Application for a Non-Material Amendment Following a Grant of Planning Permission

Planning application - a. 34 retirement apartments b. three dwellings c. associated access, car parking and landscaping (following demolition of existing buildings)

DC/21/1383/FUL

Replacing 8 Juliette balconies with full balconies on the western elevation

Scale 1:150 @ A1 Date APR 2024  
Drawn BRS Checked GSL  
Drawing No. Rev.  
**40033HH-NMA17**

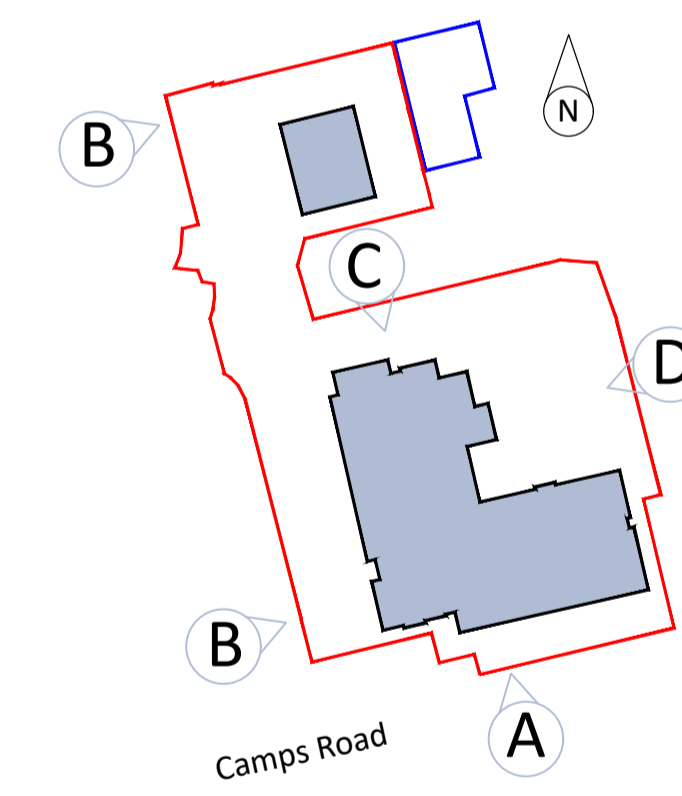
To provide additional amenity space for apartments.
